SITE AT LINGARDS ROAD - PROPOSED HOUSING			
CLIENT - S.B. HOMES LIMITED			
William Best RIBA		SITE SECTIONS: H, J, K, L, M, N, P & Q	
The Chapel House, 22, Pole Gate, Sarnammonden, West Yorkshire, HD3 3FW. Tel 01484 845886 Mob 07828 481144		SCALE	DATE
		1:200	04-03-2020
		WB	2019-572-15 G

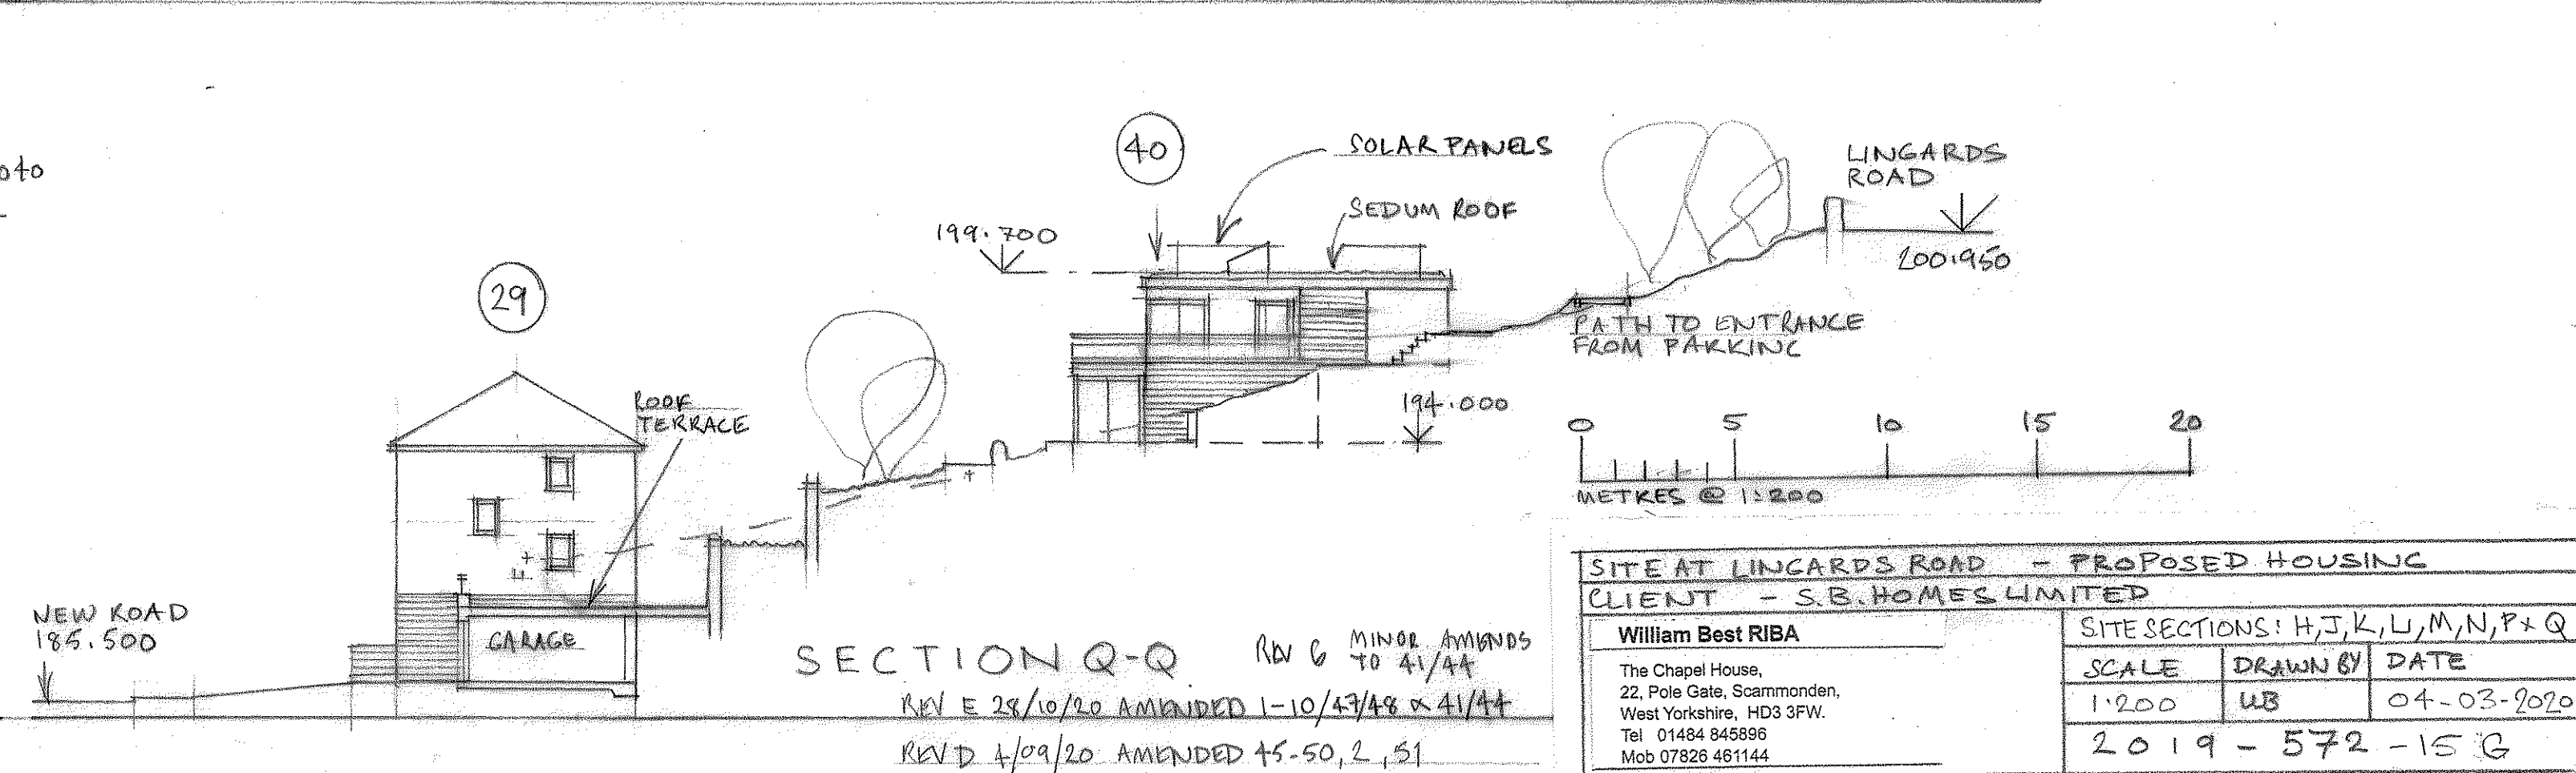
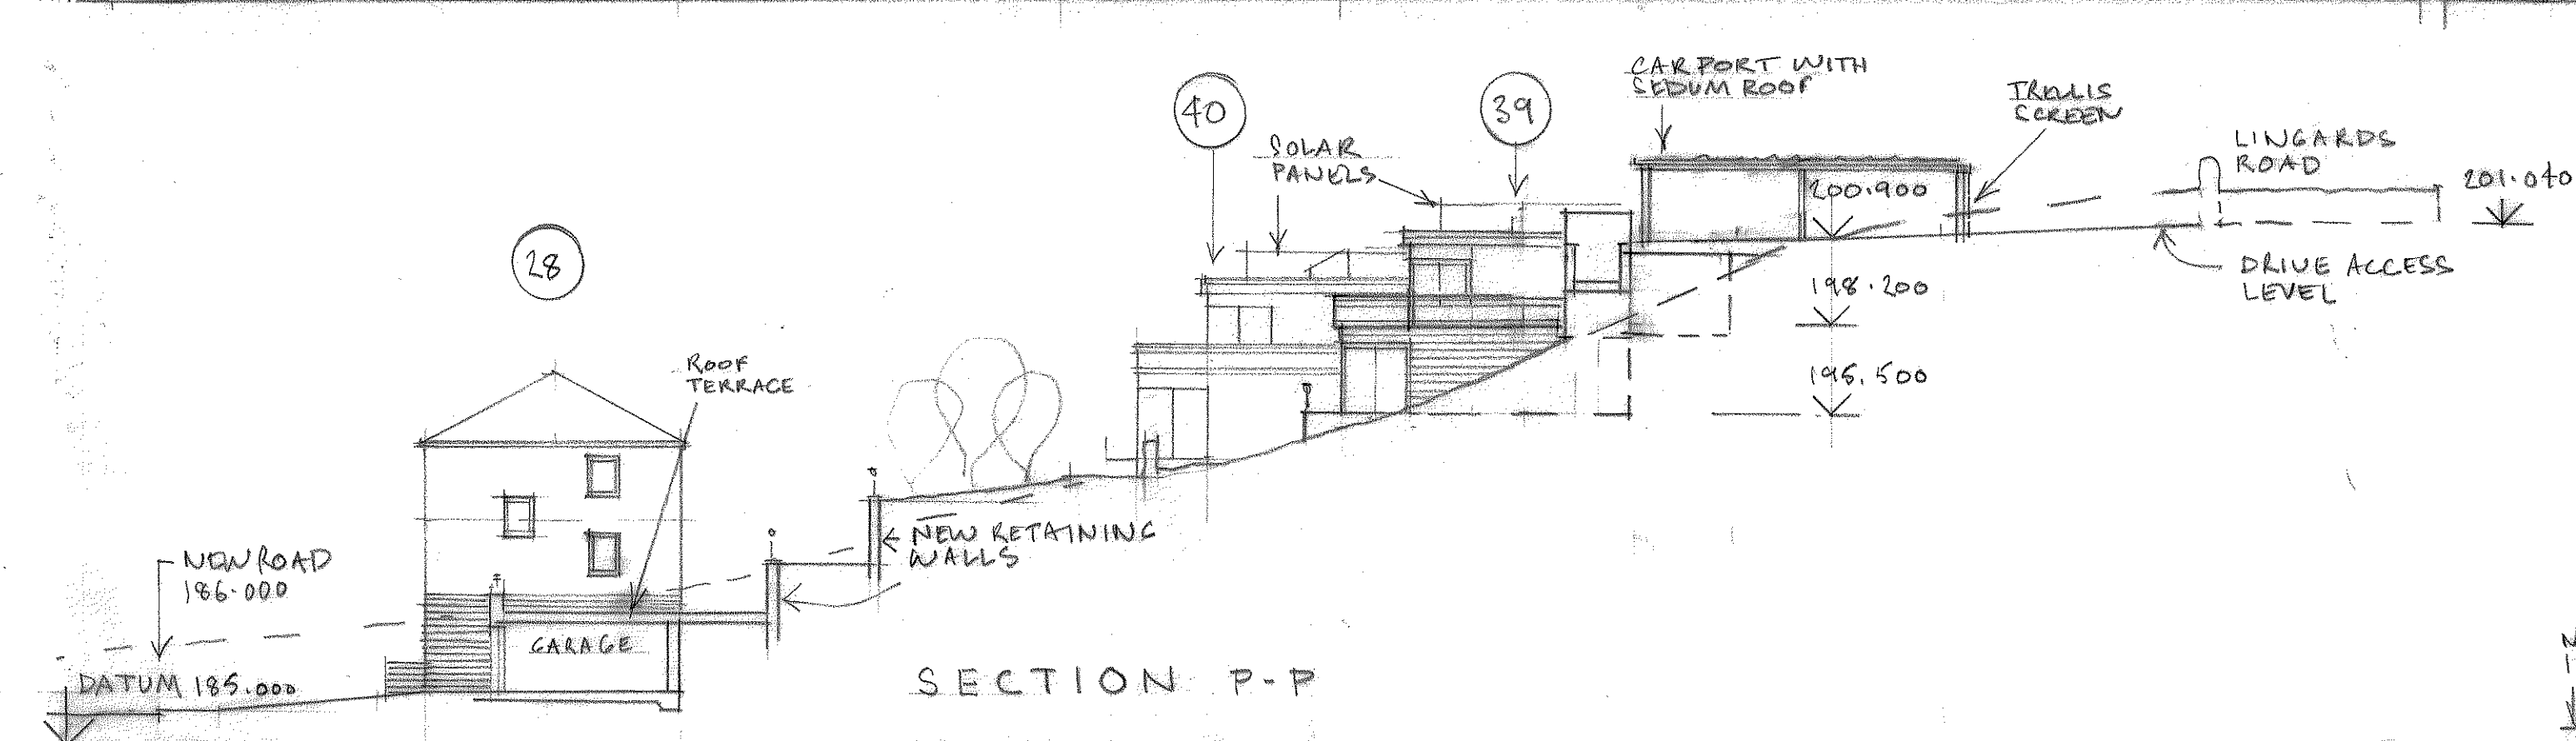
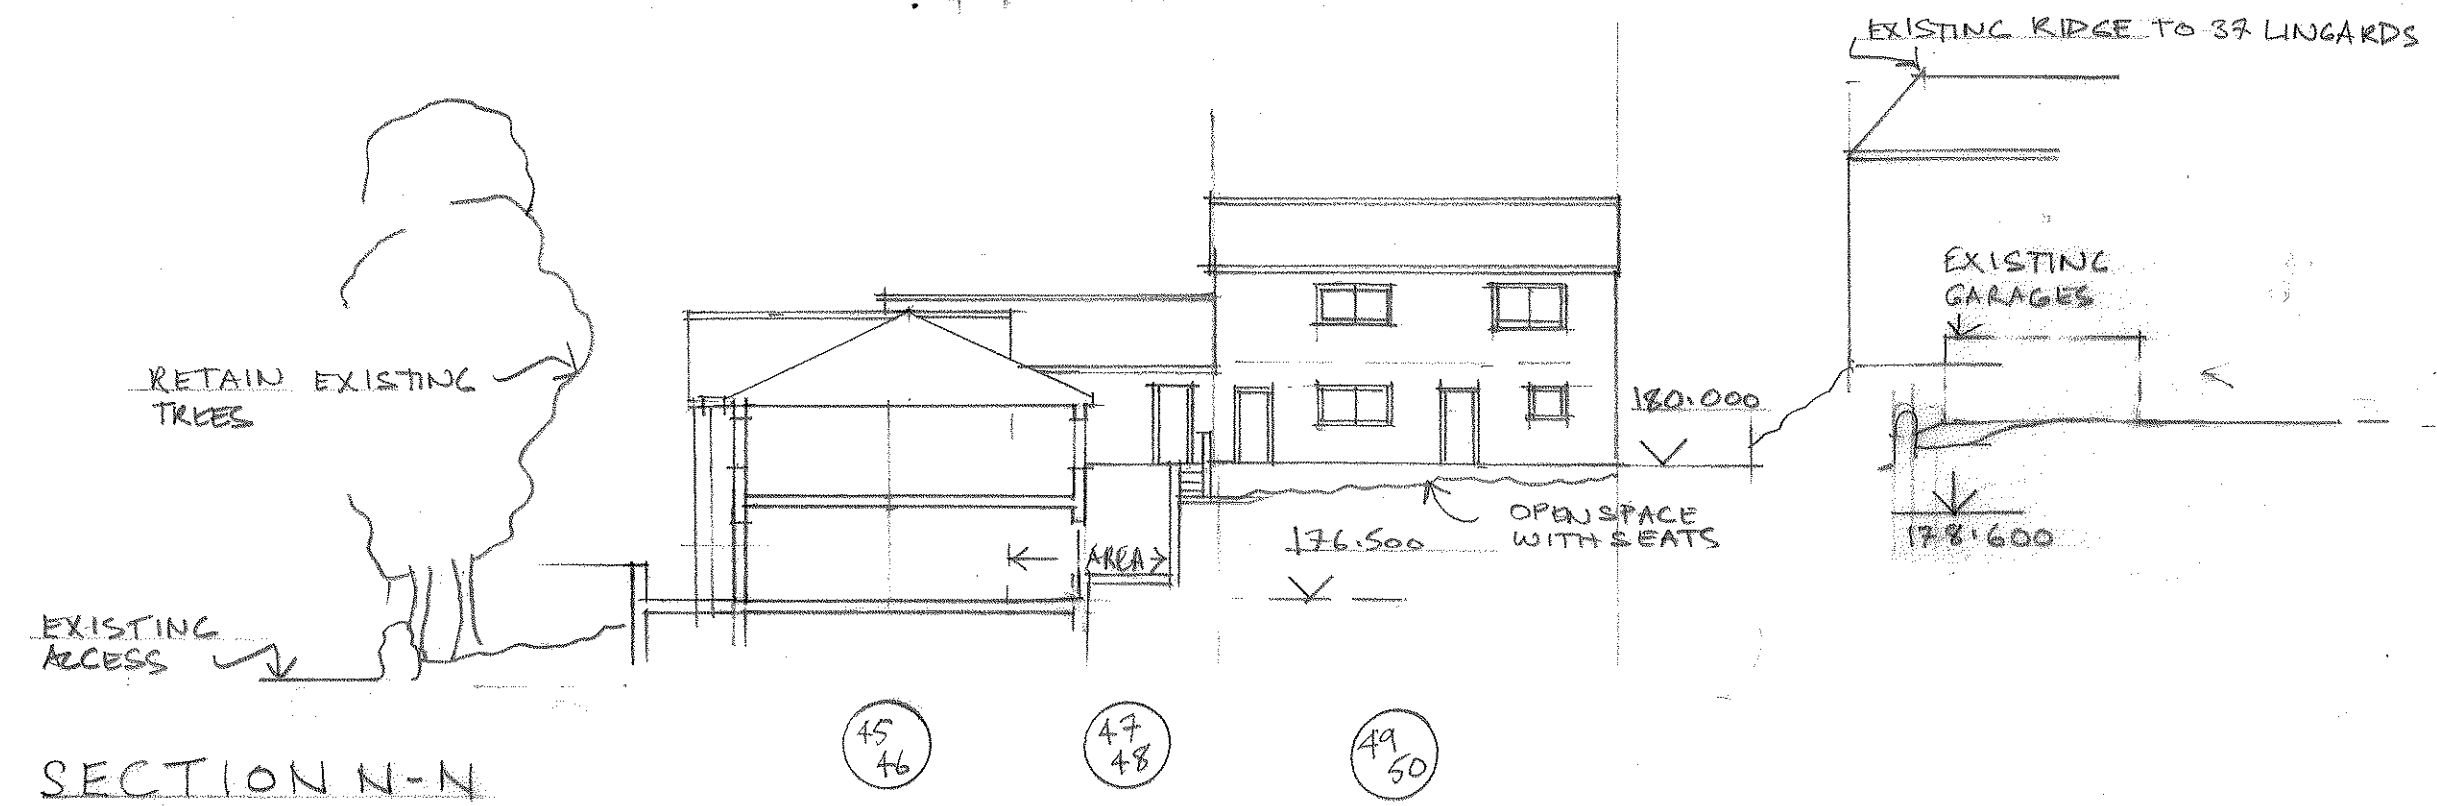
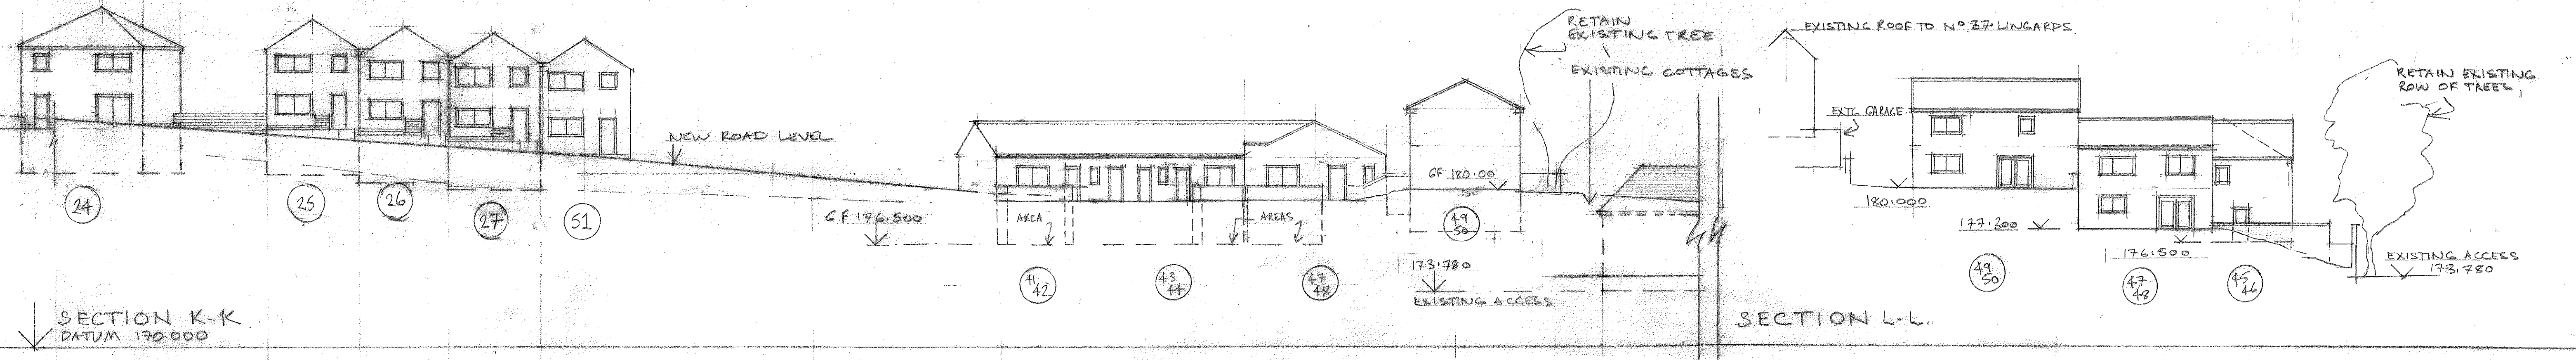
The foundations, at the northern most point, for plot 34, are proposed to be ~3.68m above existing ground level: *see image right.*

To achieve that, infill material would be needed.

A valid question is, how much infill material would be required?

Taking a conservative estimate, it would require approximately 276 metric tonnes of compacted soil.

The terrace, proposed for the rear, would require infill too.

So, even though the applicant refers to dwellings following the contours, it's simply amazing just how much infill would be required to achieve that.

To my mind, following contours would not require very much infill at all, if any.

To my mind, requiring so much infill suggests the proposed dwellings are not suitable for where they are proposed.
